SITE PLAN

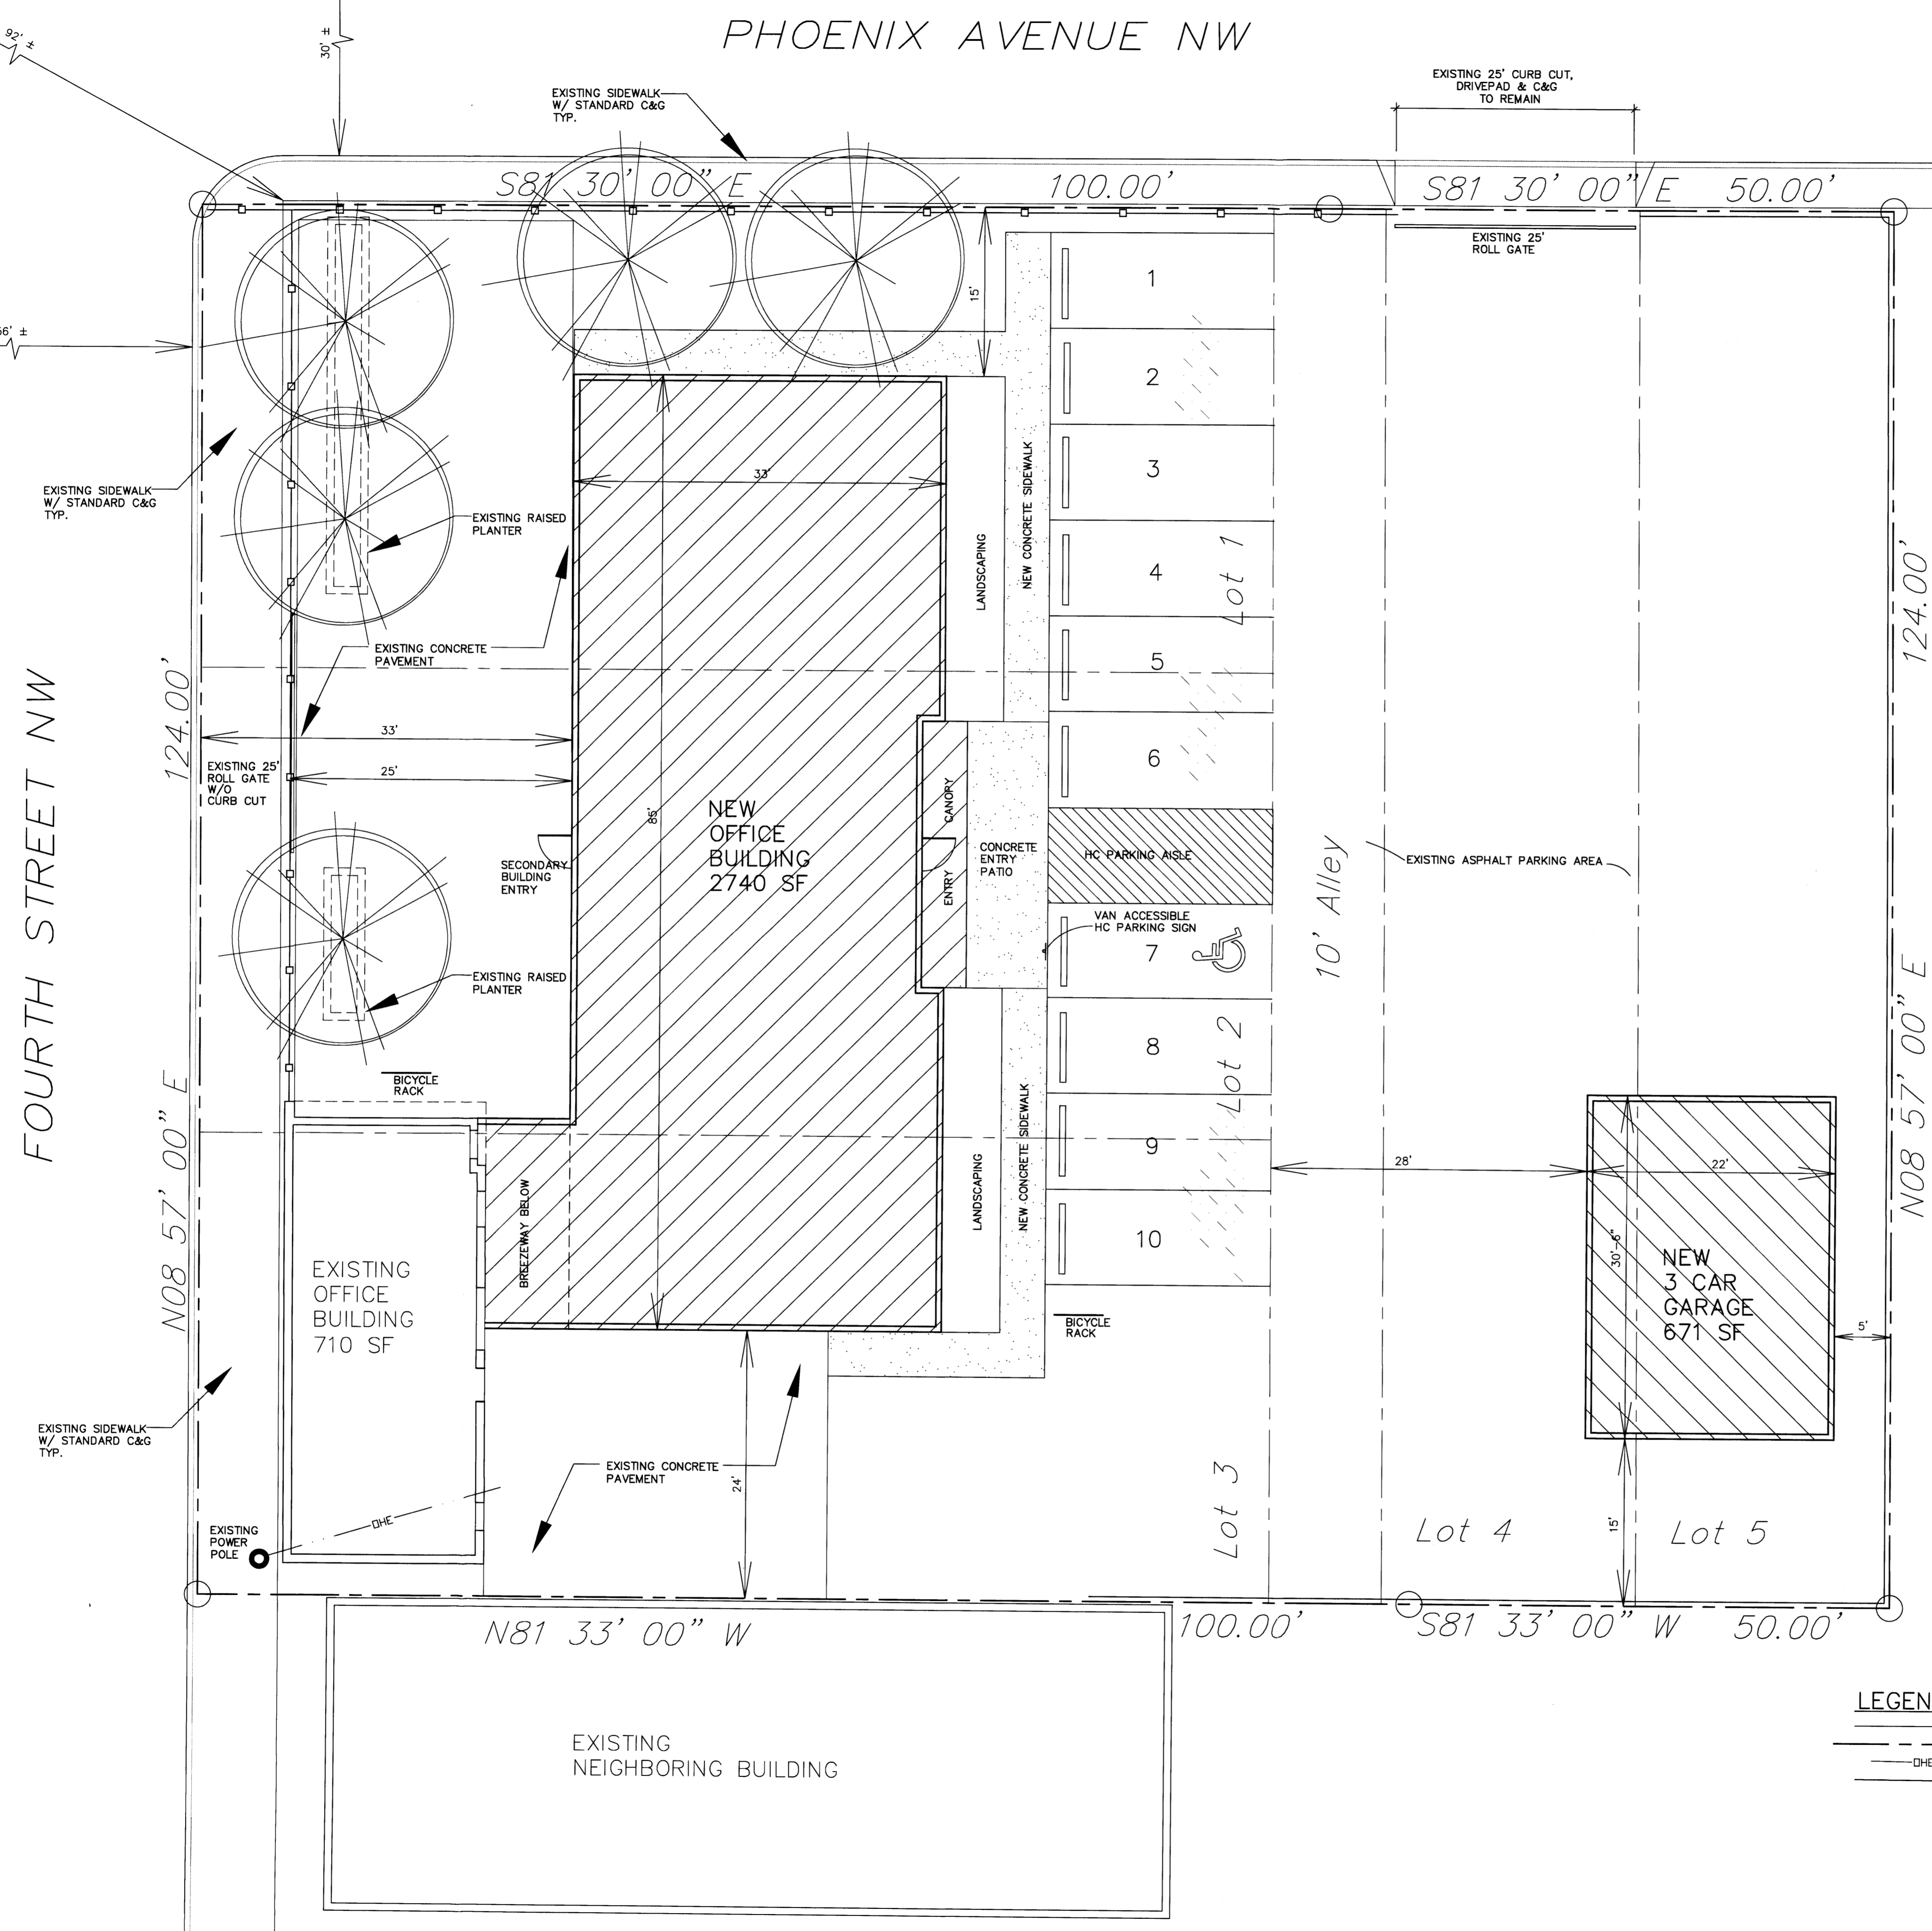
ISSUES CONCERNING PLATTING OF ACCESS ESM'T "ACROSS" RUEY (PUBLIC P/W) MUST BE PROCESSED THRU DRB AT SKETCH PLAT REVIEW (PER SUBDIVISION ORDINANCE) ADDITIONS → SEE PG 48. RESTRICTIONS ON BUDG BUT DO NOT HAVE TO FOLLOW A BUDG FORM TYPE. MUST COMPLY W/ALL OTHER STDS. (PG 29-33) IF NEW MUST MEET ALL REQ'MENTS - BUDG. MUST FRONT ON 4TH STREET.

TRANSPORTATION. CURB OUT ON PHY AVE. NOT 4TH ST. CAN CONTINUE TO USE THE EXISTING.

- FM - DRIVEABLE SERVICE. LIMITED ACCESS THRU GATE. LOCK BOX FOR FIRE. 20' UNOBSTRUCTED. APP'D SIDE PLAN
- SITE PLAN NEED TO SHOW PARKING LAYOUT. <sup>PROF TO BUILDING</sup> PERMIT.
- DUMPSTER. TAKE TO SOLID WASTE.
- HYDRANT LOCATIONS ON SITE PLAN.
